BOY SCOUTS OF AMERICA®
PIKES PEAK COUNCIL

June 2, 2020

Subject: LETTER OF INTENT for Glen Aspen Ranch a Pikes Peak Council Inc,
Boy Scouts of America– Special Use Permit for Campground - Revised

SITE PLAN

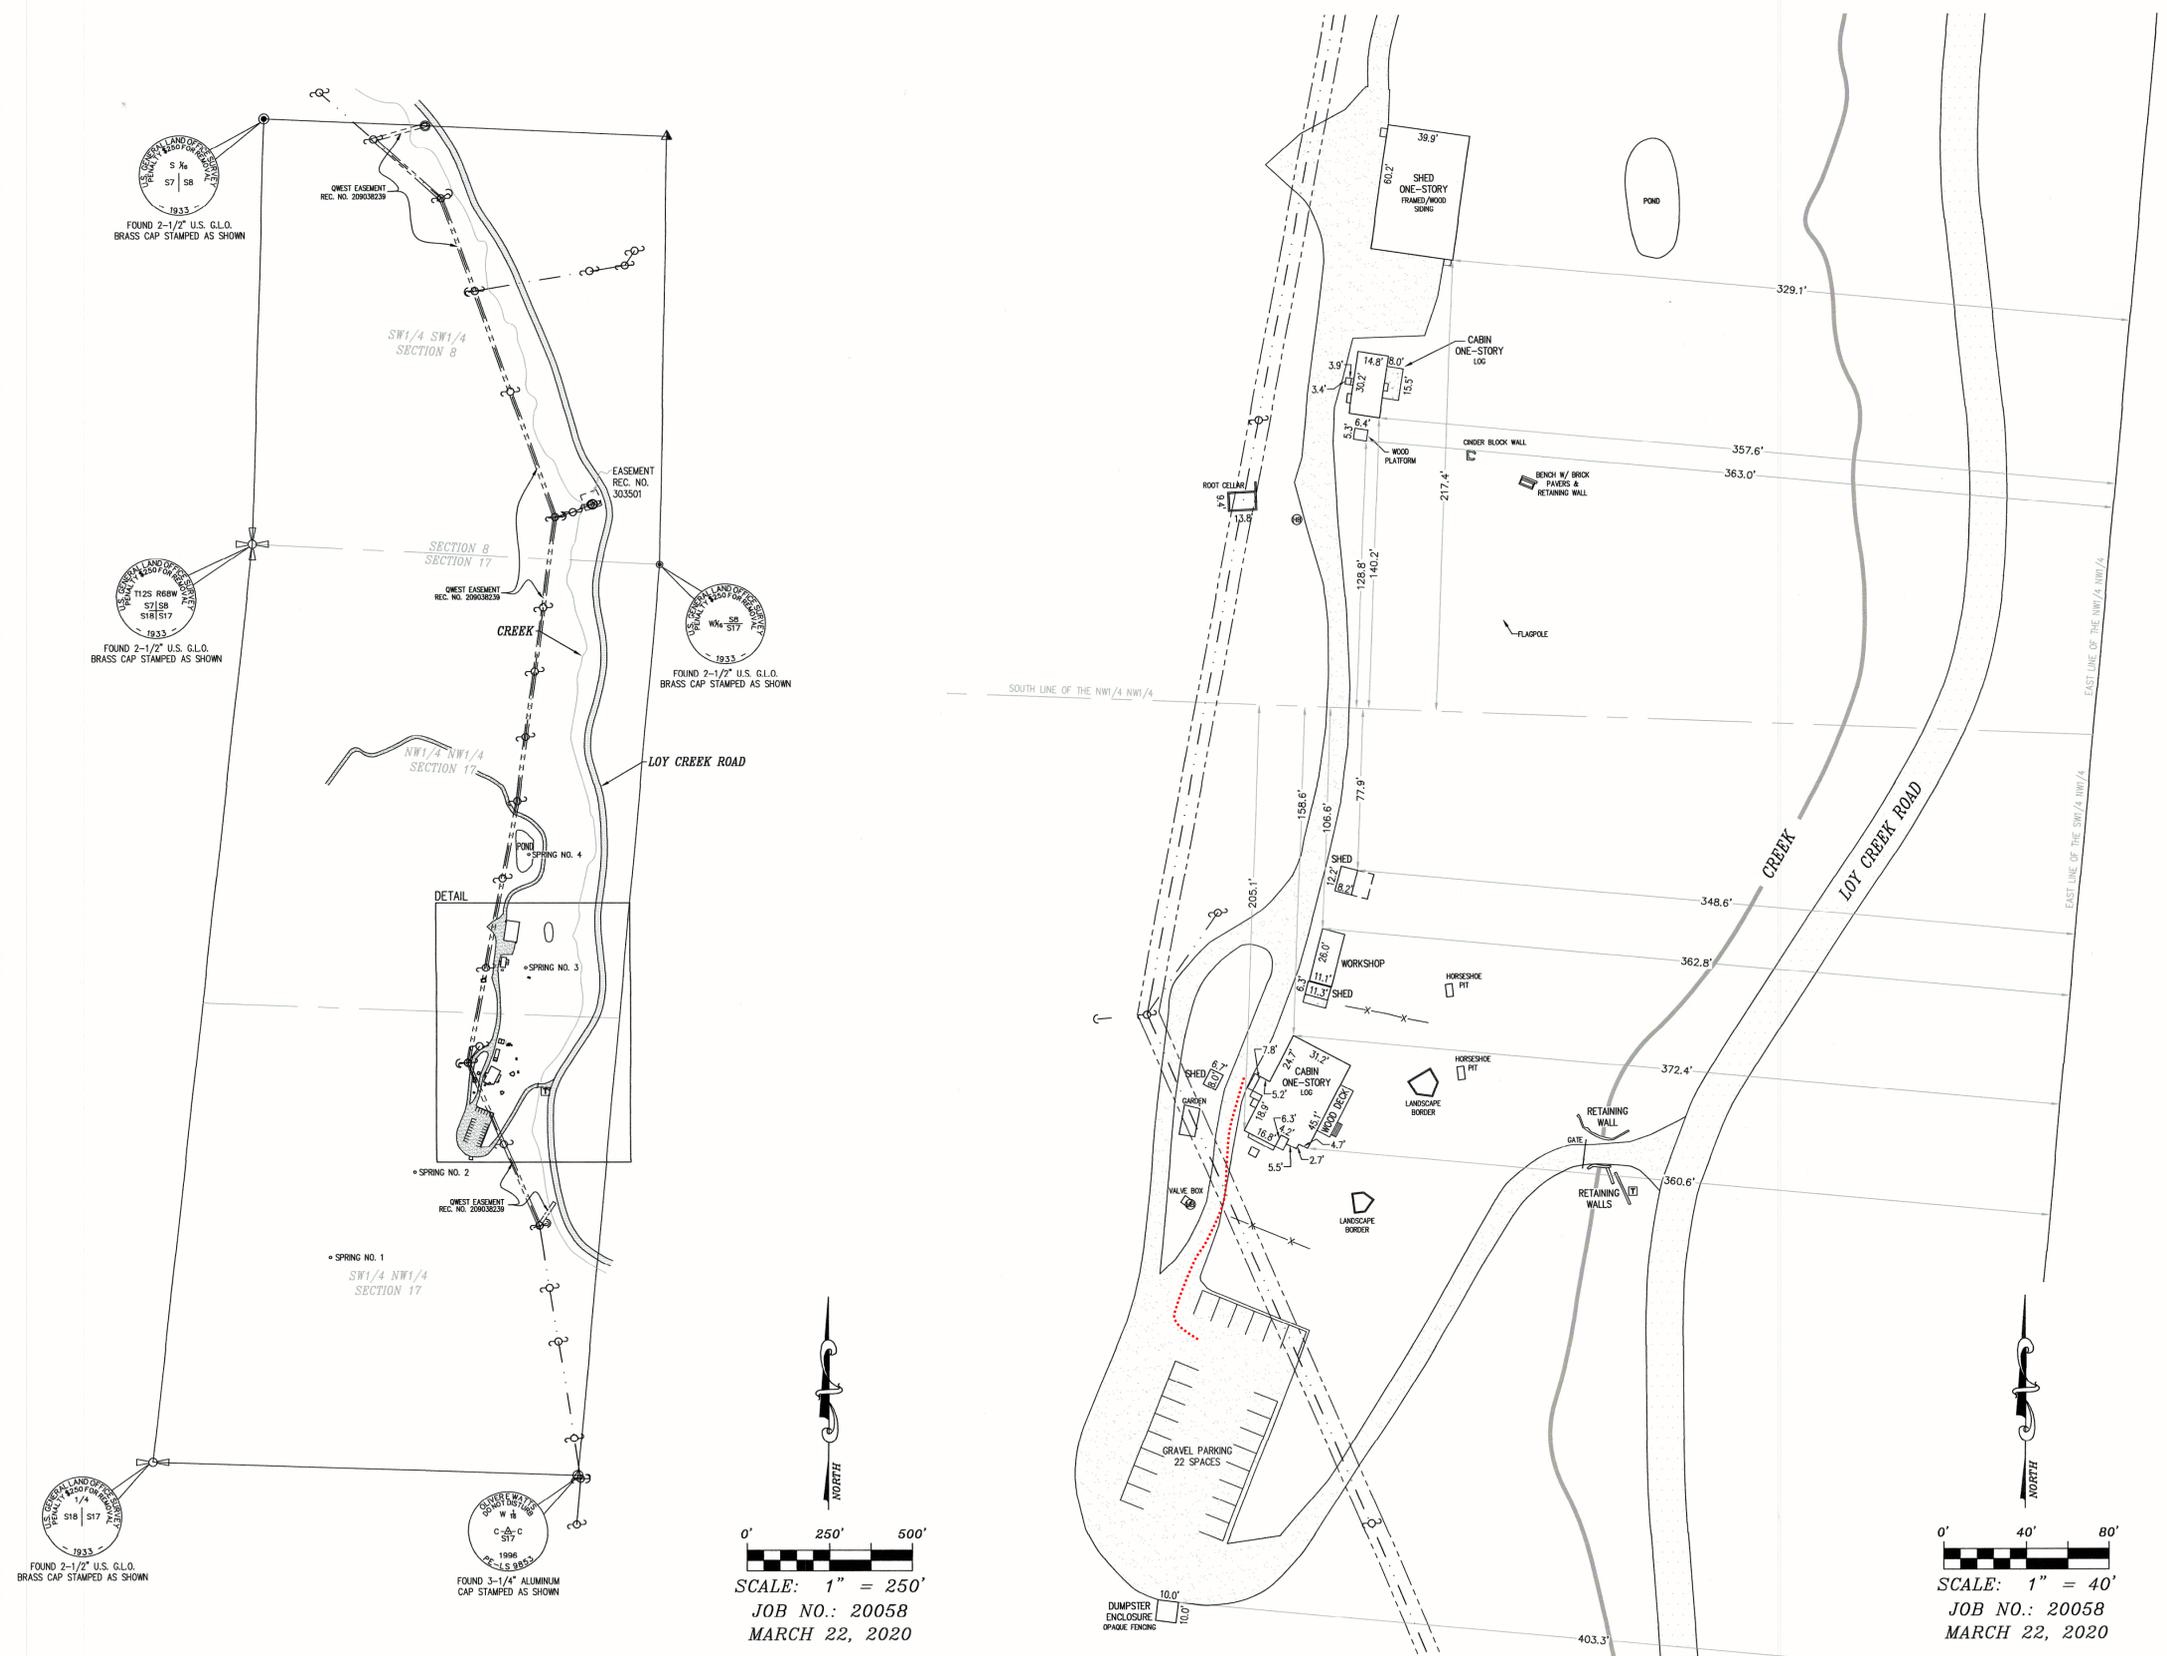
Requested Clarification: "Provide justification and explanation of why 22 spaces is adequate within the Letter of Intent, also provide exact dimensions of each parking spaces. Please provide justification and explanation and an explanation of why 22 spaces is adequate. Also explain how the parking spaces will be delineated/marked as this is a gravel lot."

Requested Clarification: “Provide an ADA route on the site plans that show circulation from the parking lot to the cabin and provide that route in the legend.”

Required number of parking spaces for our requested use is not called out in the tables in the code in Chapter 6. We laid out a number of spaces that would fit easily into the area of the parking area. Our groups usually have 20 to 30 people and we typically have room for 2 groups at a time. Smaller groups would allow for more groups but normal capacity would be 60. Scout Troop typically carpool with one leader driving with 2 or 3 youth in the car (3 to 4 per car). So using 60 participants divide by average people per vehicle gives us a requirement for 15 to 20 spaces.

The spaces were determined by allowing for a slot width for each vehicle of 10 feet and depth of 19 feet. Drive down the middle is 22 feet wide.

The spaces will be delineated by wood post buried in ground at the front end of every space. Side lines may be painted on the ground with marking paint. Paint may need to be updated during season. (Added May 29, 2020)

Site plan was updated with path from parking to Homestead. Comment added May 29, 2020.

SITE PLAN

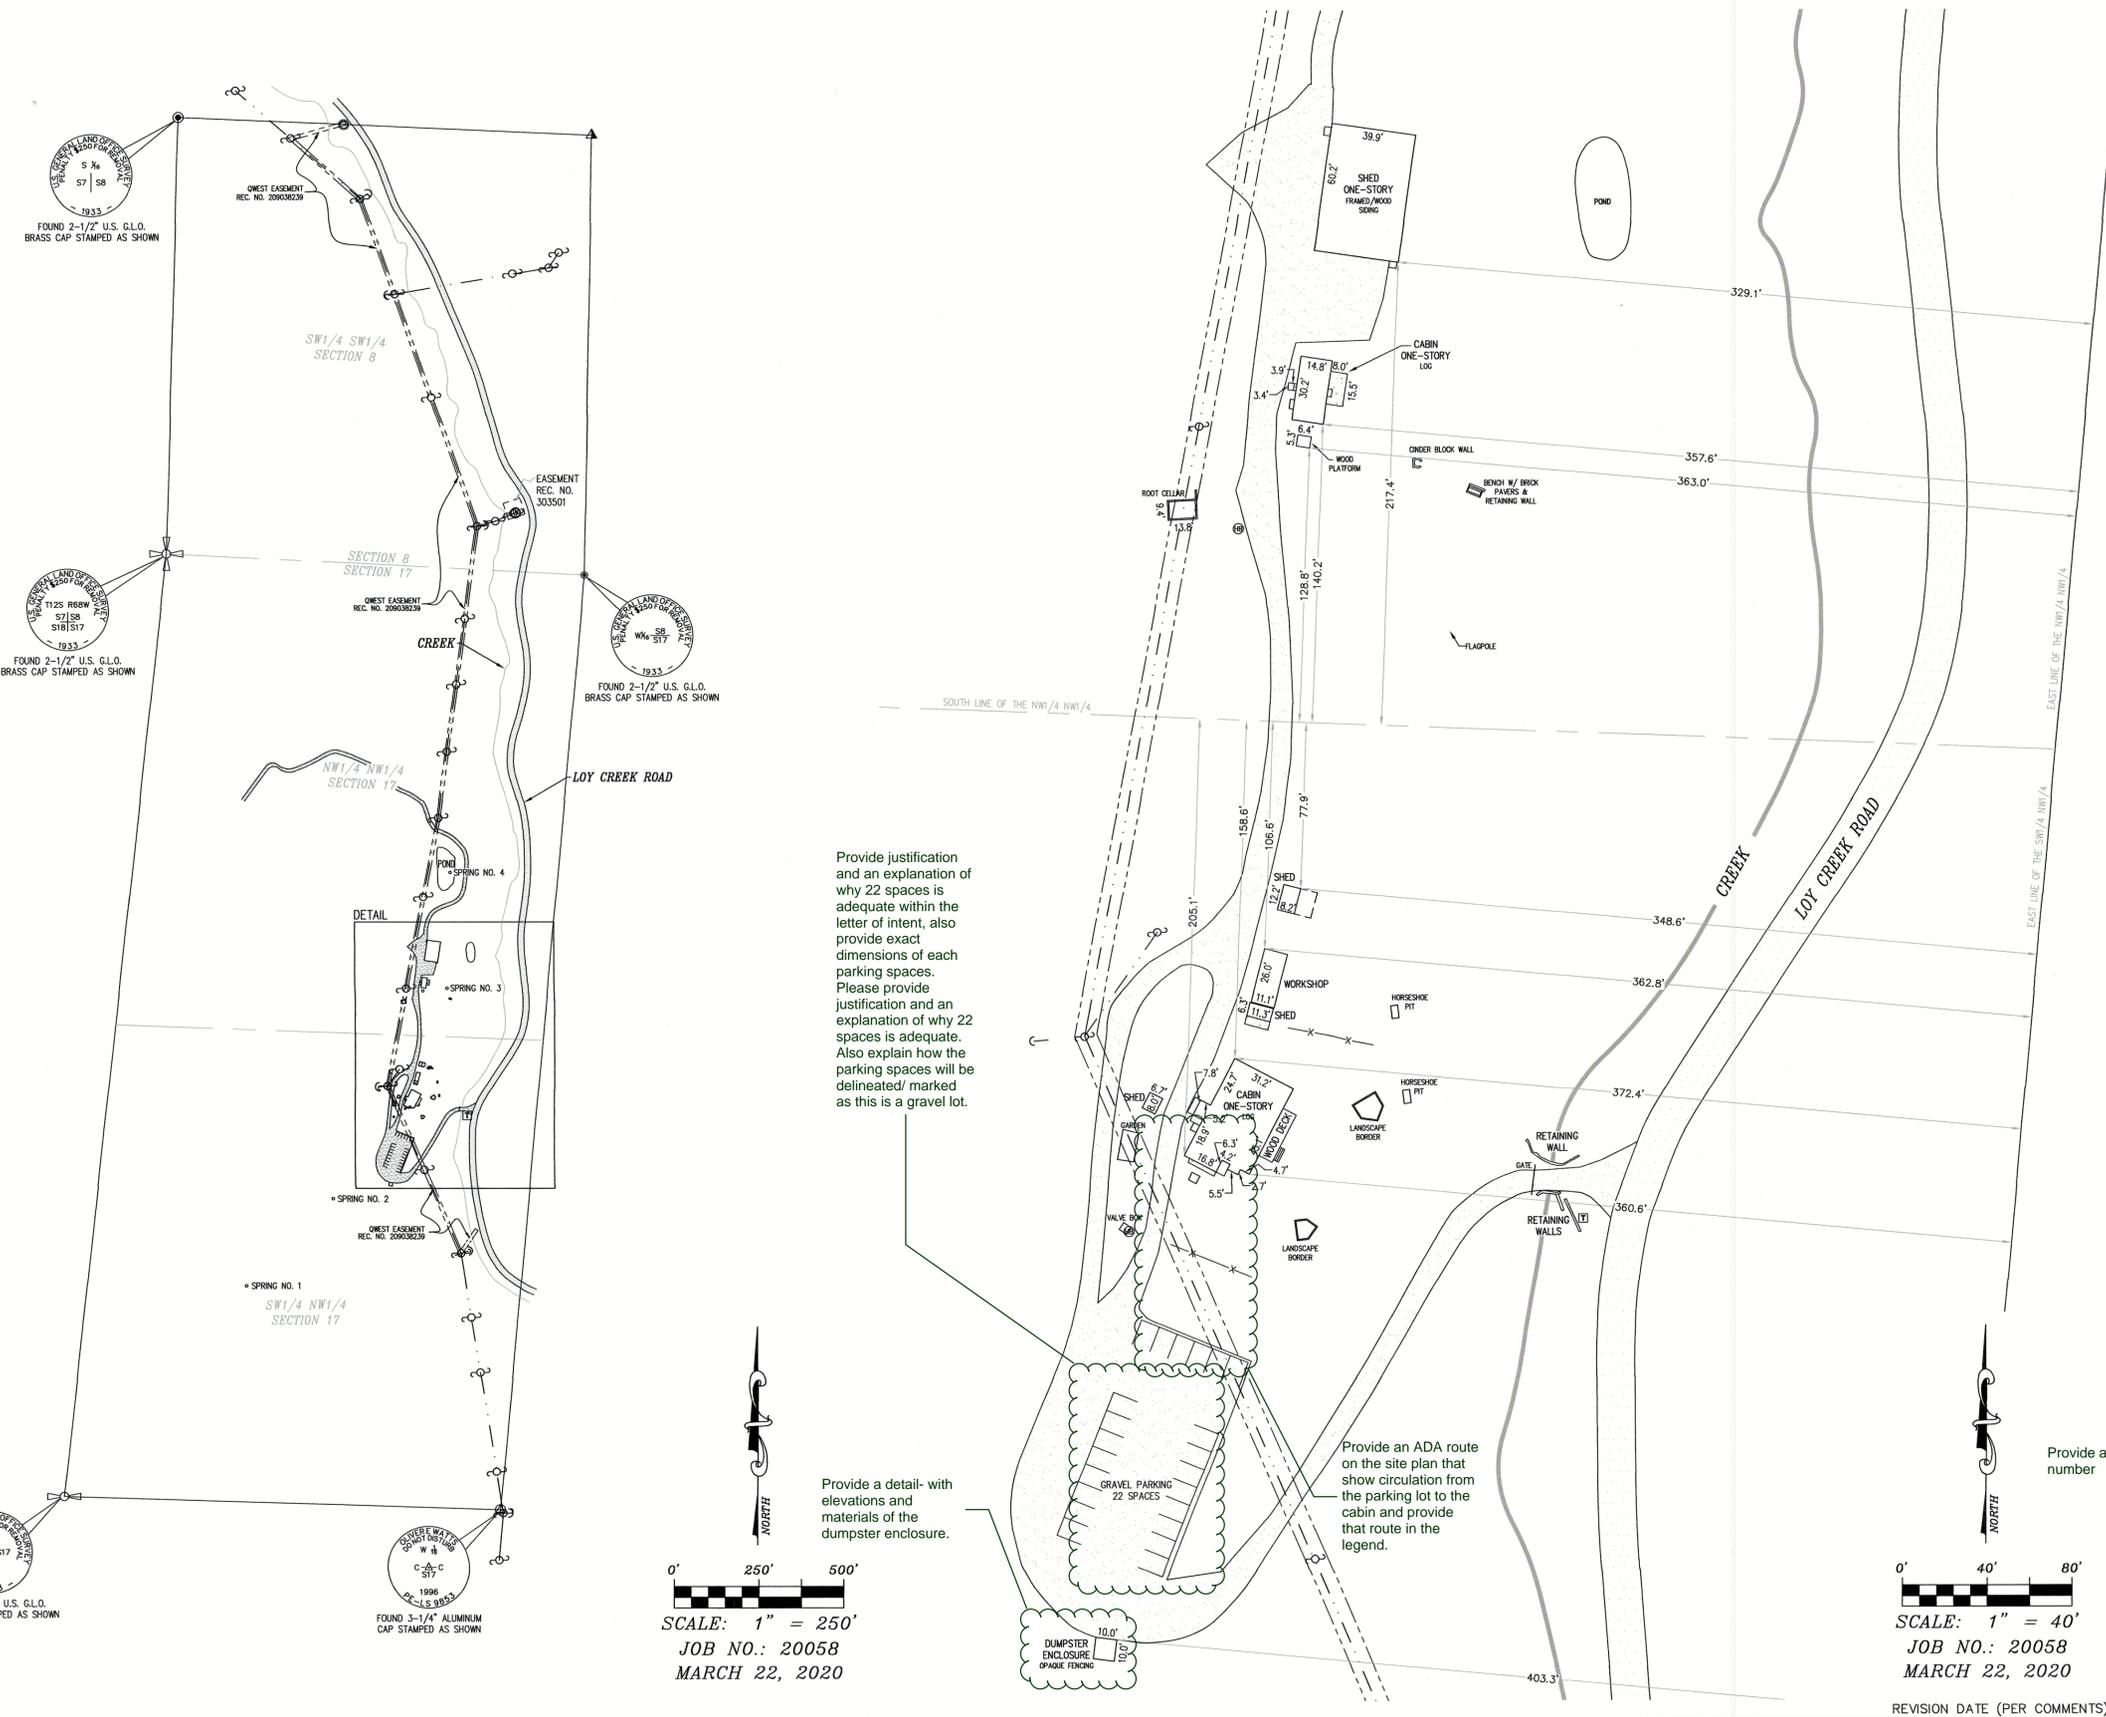
Requested Clarification: **“Provide a detail with elevations and materials of the dumpster enclosure.” The purpose of this enclosure is to provide visual harmony with the surrounding community and block view of the dumpster from those passing the property from the road.**

Our dumpster is bear proof with padlocked bars on each opening. Dumpster enclosure will be 3 sided wood fencing with the back side open to the forest. The front side will be gates to allow access to the removal company. We will use the following materials:

4 x4 post, 2x4 rails, cedar fence pickets 6ft tall, concrete for posts, dimensions 10ft x 10ft X 6ft.
